DRB Application No.: 06DRB-01391(P&F)  
Project Name RICE DURANES ADDITION #1  
Agent: Surveys Southwest

**PROJECT # 1005167          APPLICATION # 06-01391**

**RE: Lot 15, Rice Duranes Addition #1/p&f**

PLAT OF
 LOTS 15-A & 15-B
 RICE DURANES ADDITION No.1
 SITUATE WITHIN PROJECTED SECTION 7,
 T. 10 N., R. 3 E., N.M.P.M.
 TOWN OF ALBUQUERQUE GRANT
 CITY OF ALBUQUERQUE
 BERNALILLO COUNTY, NEW MEXICO
 AUGUST 2006

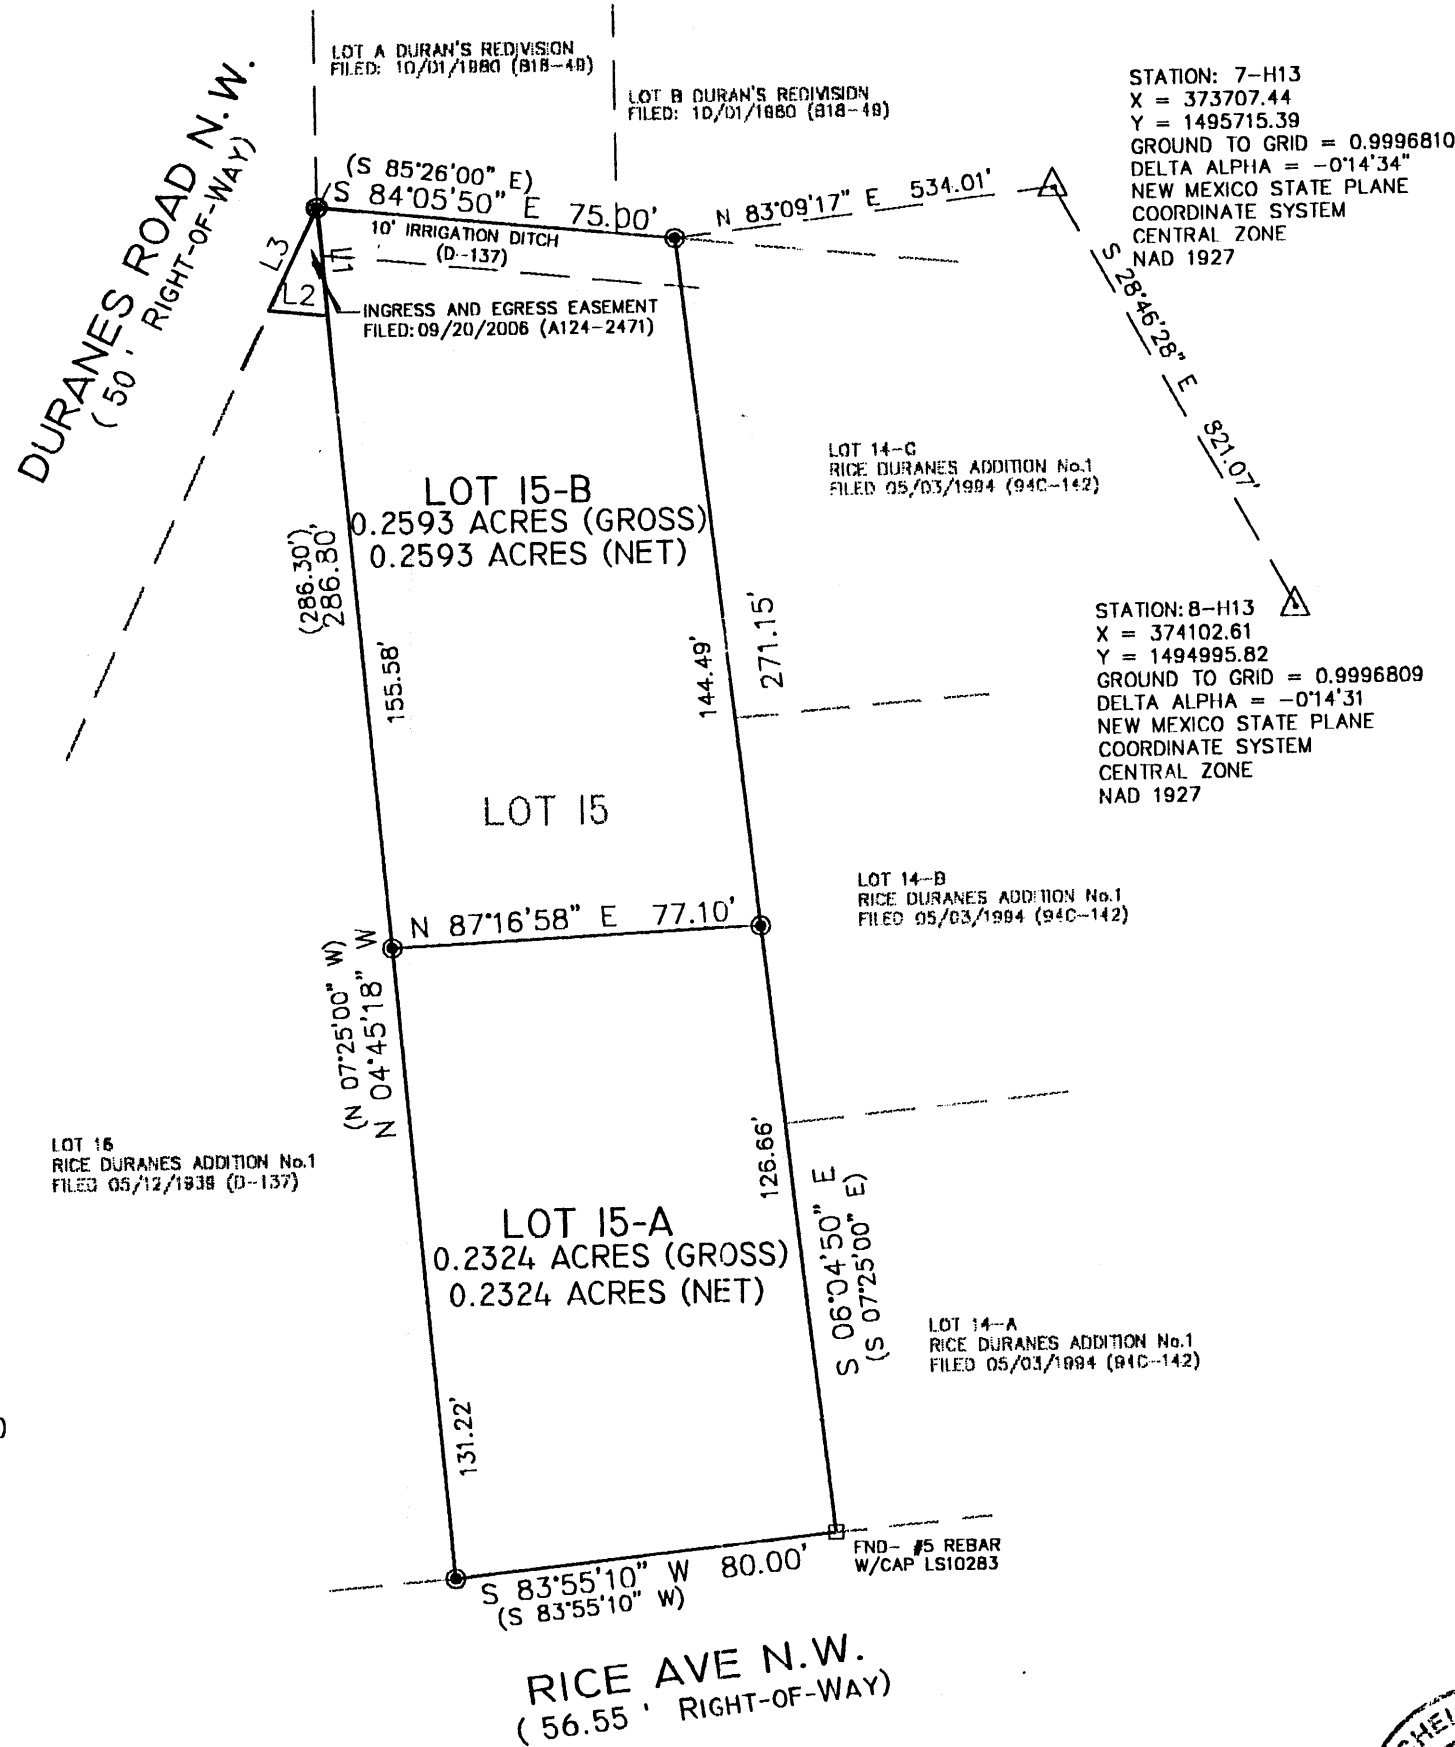
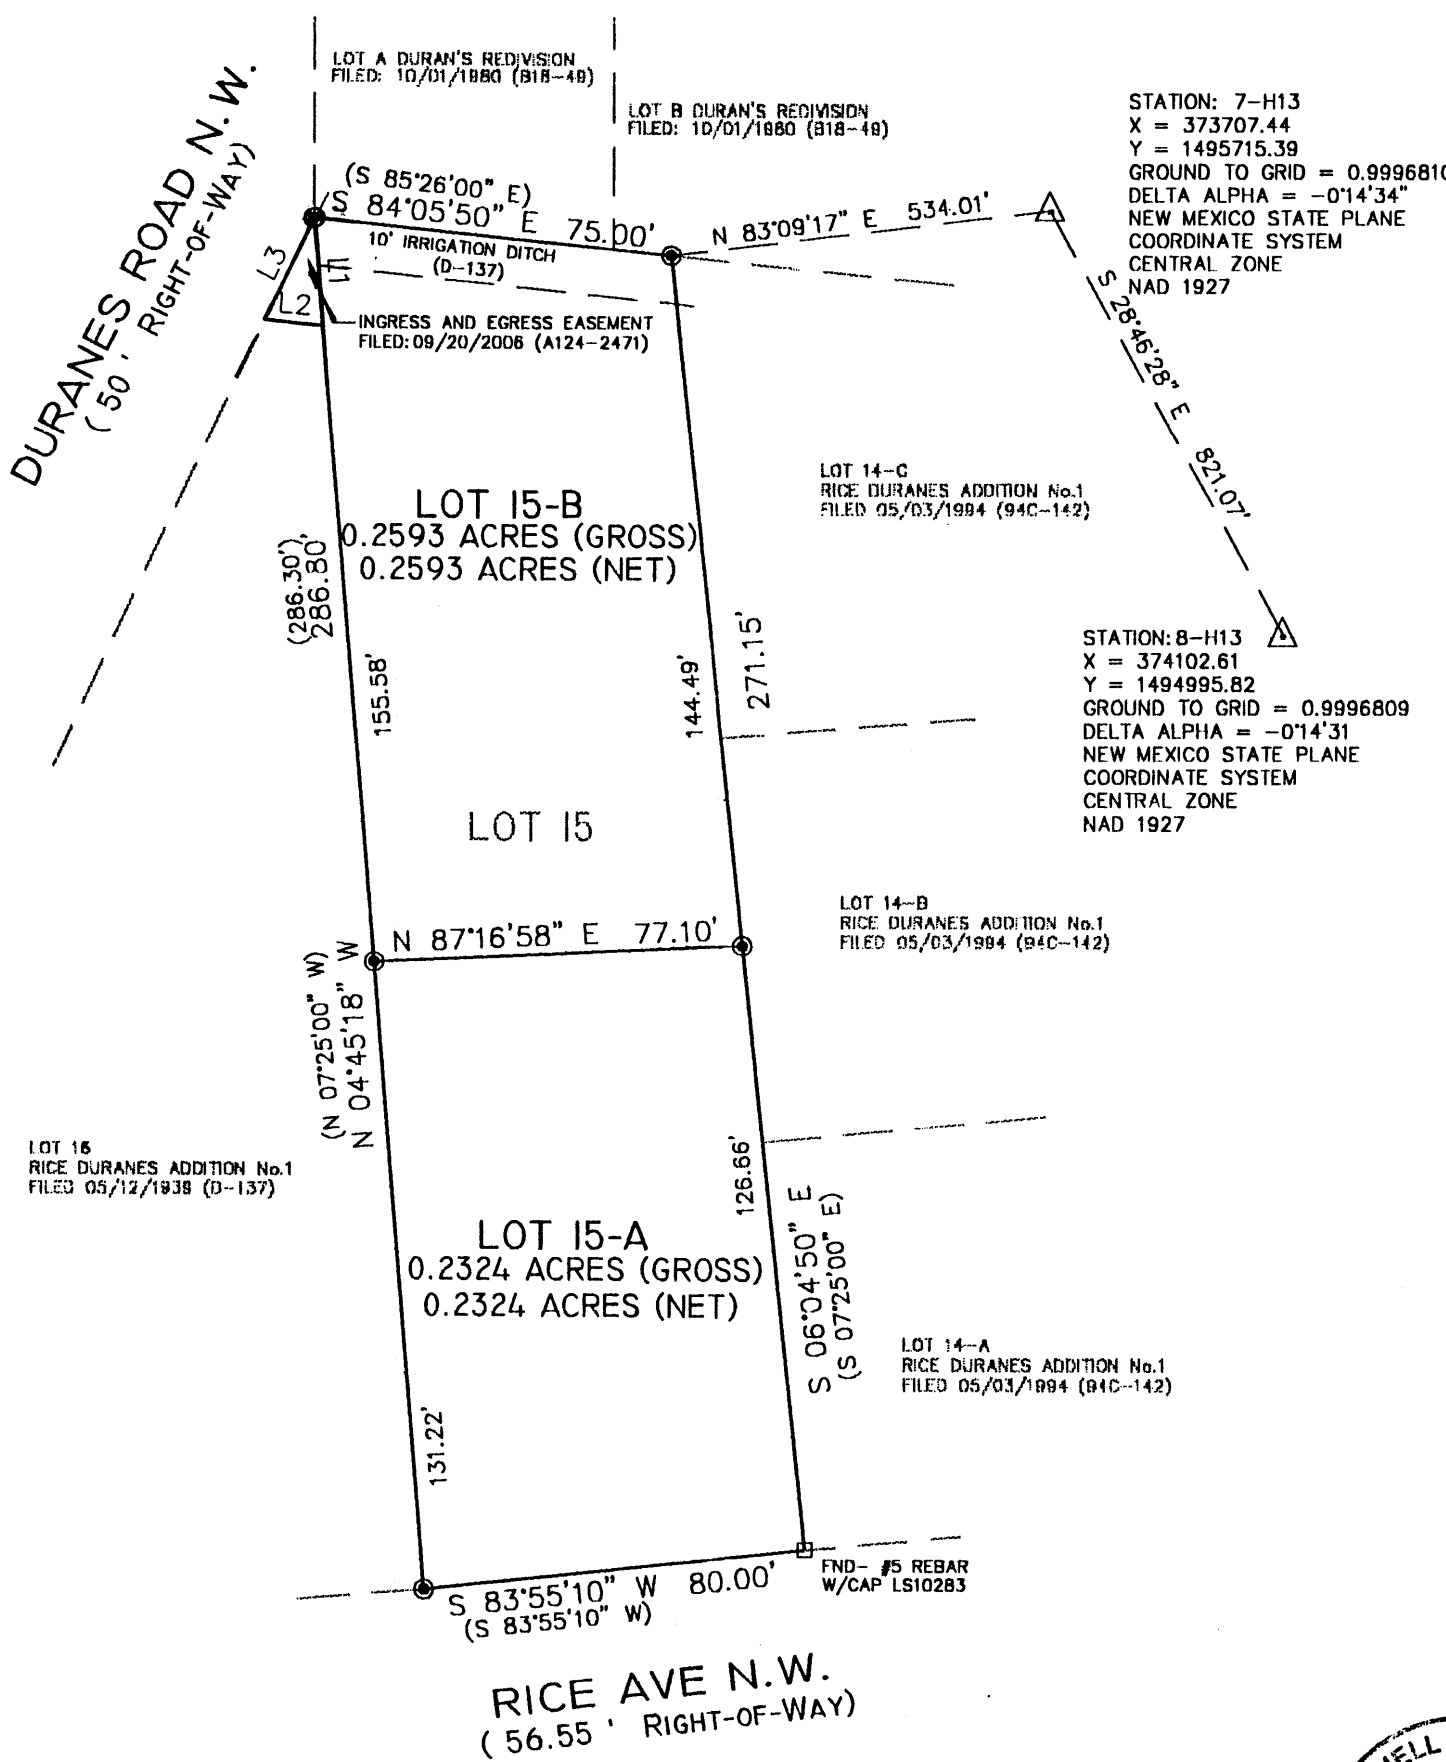
UTILITIES: open new water/sewer account @ town  
contract, also get tapping permits for new  
service connections

1. There appears to be one water/sewer account for the existing development. In order to subdivide, separate water and sewer service connections will need to be made for the duplexes and a new account created.
2. Private water/sewer service easements are required for access to either Duranes Road or Rice Avenue.
